Sydney Metro Martin Place

North Tower Base Building Changes

SSD/ MOD drawings & FC2 Comparison

Rev #02 – 26/10/21

Extract from approved northern elevation (extract)

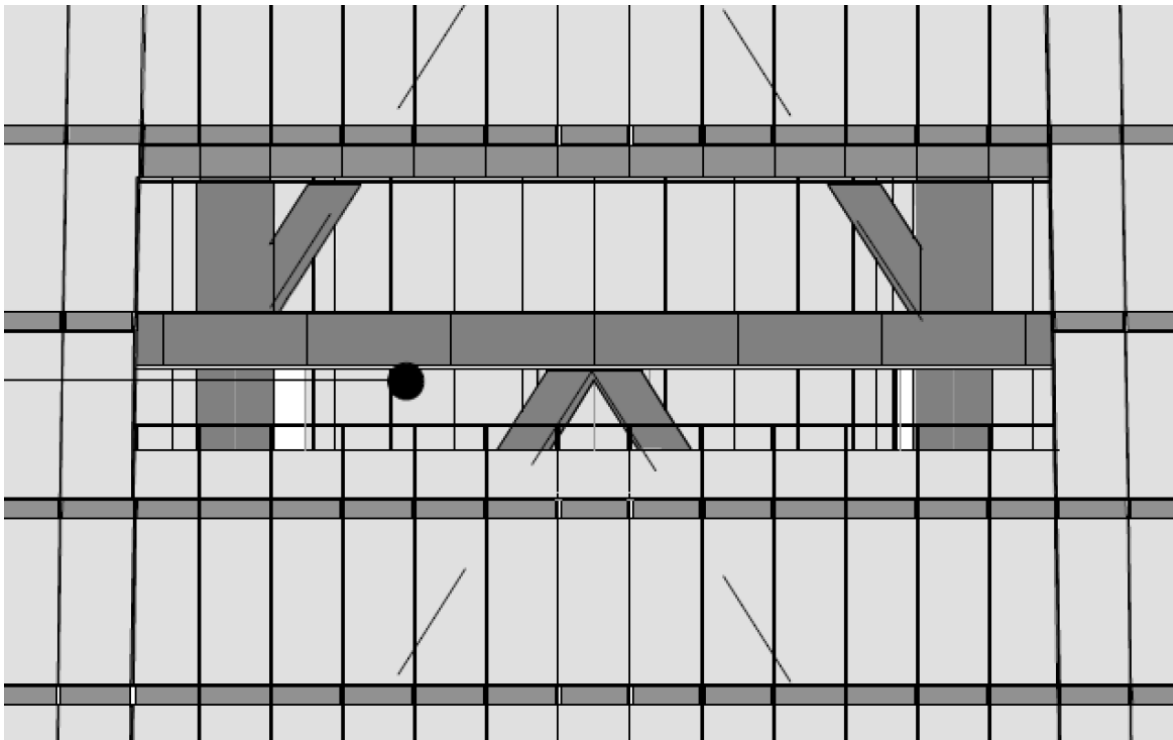
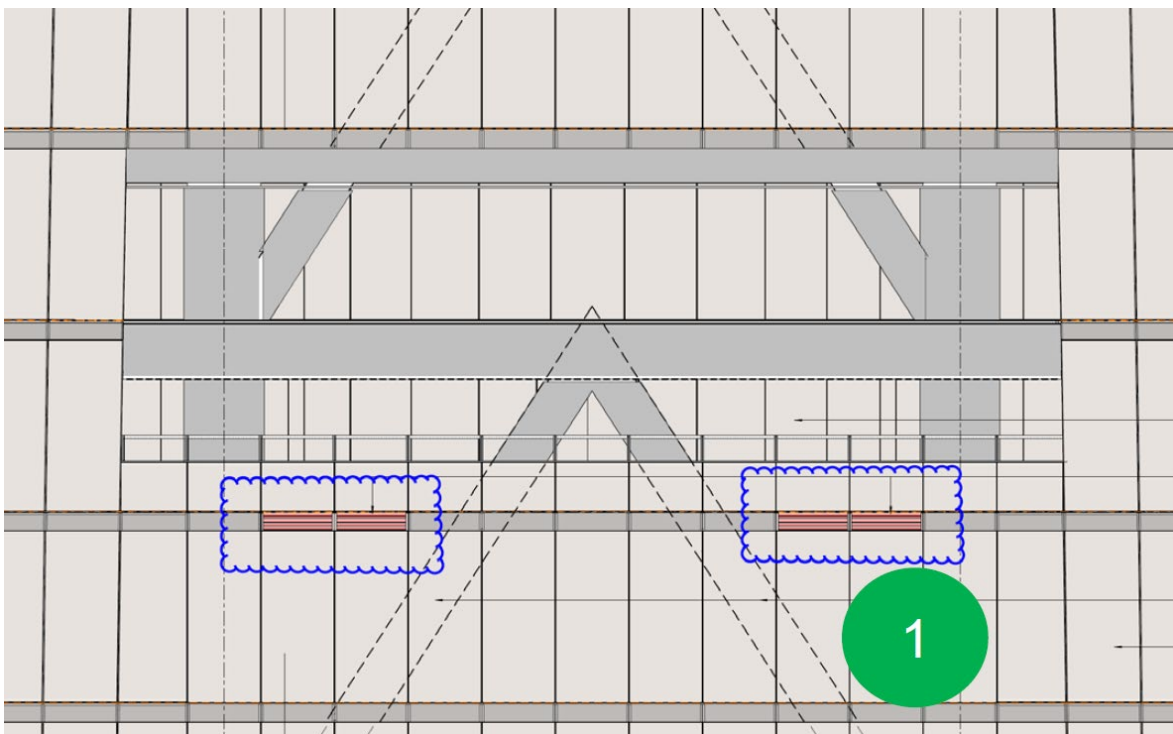
- 1.Additional generator flues
- 2.Kitchen exhaust added
- 3.Balustrade height increased

Figure 2 Comparison of approved upper roof BMU openings (outlined red) and proposed reduced BMU openings (outlined in black) – south elevation

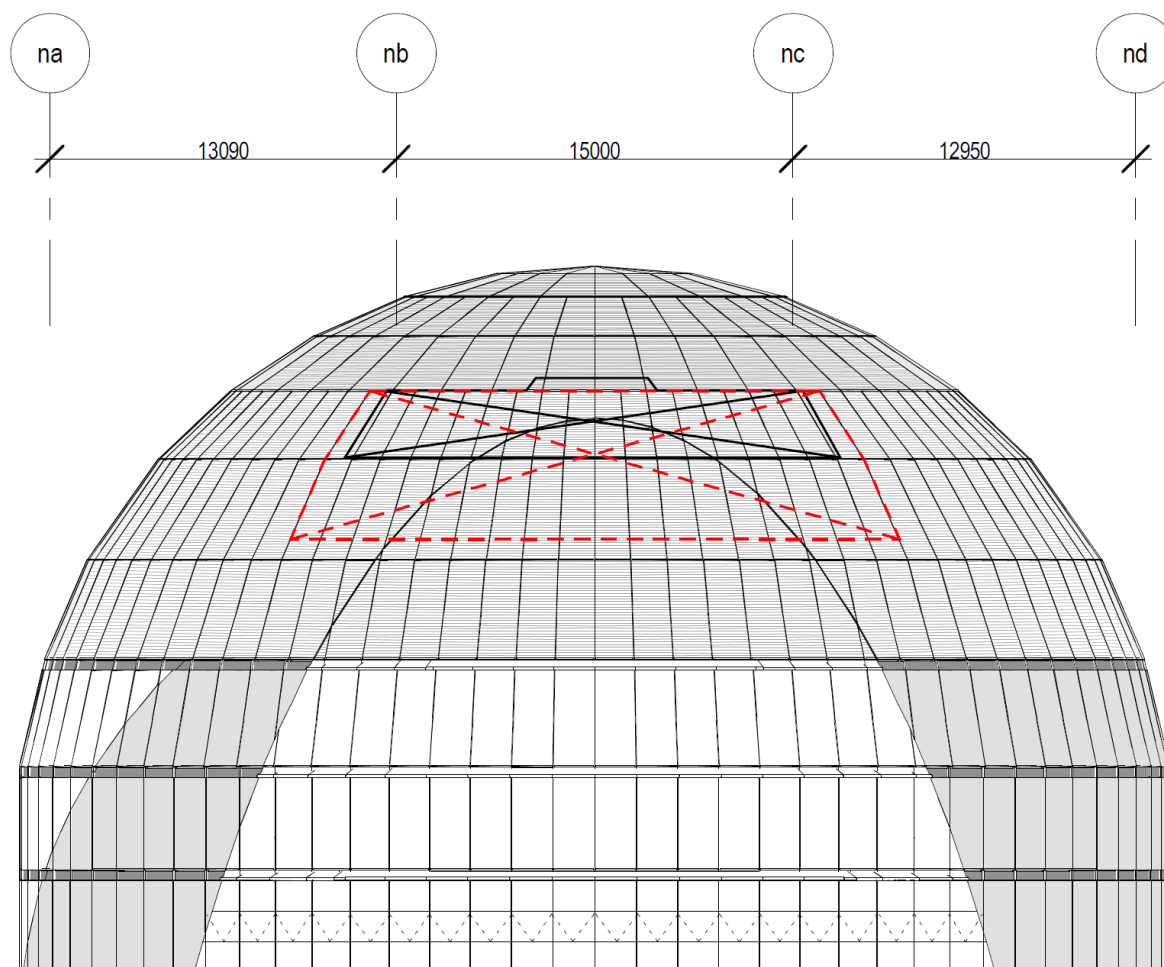
- 1.Plant layout revised
- 2.BMU hatch reduced
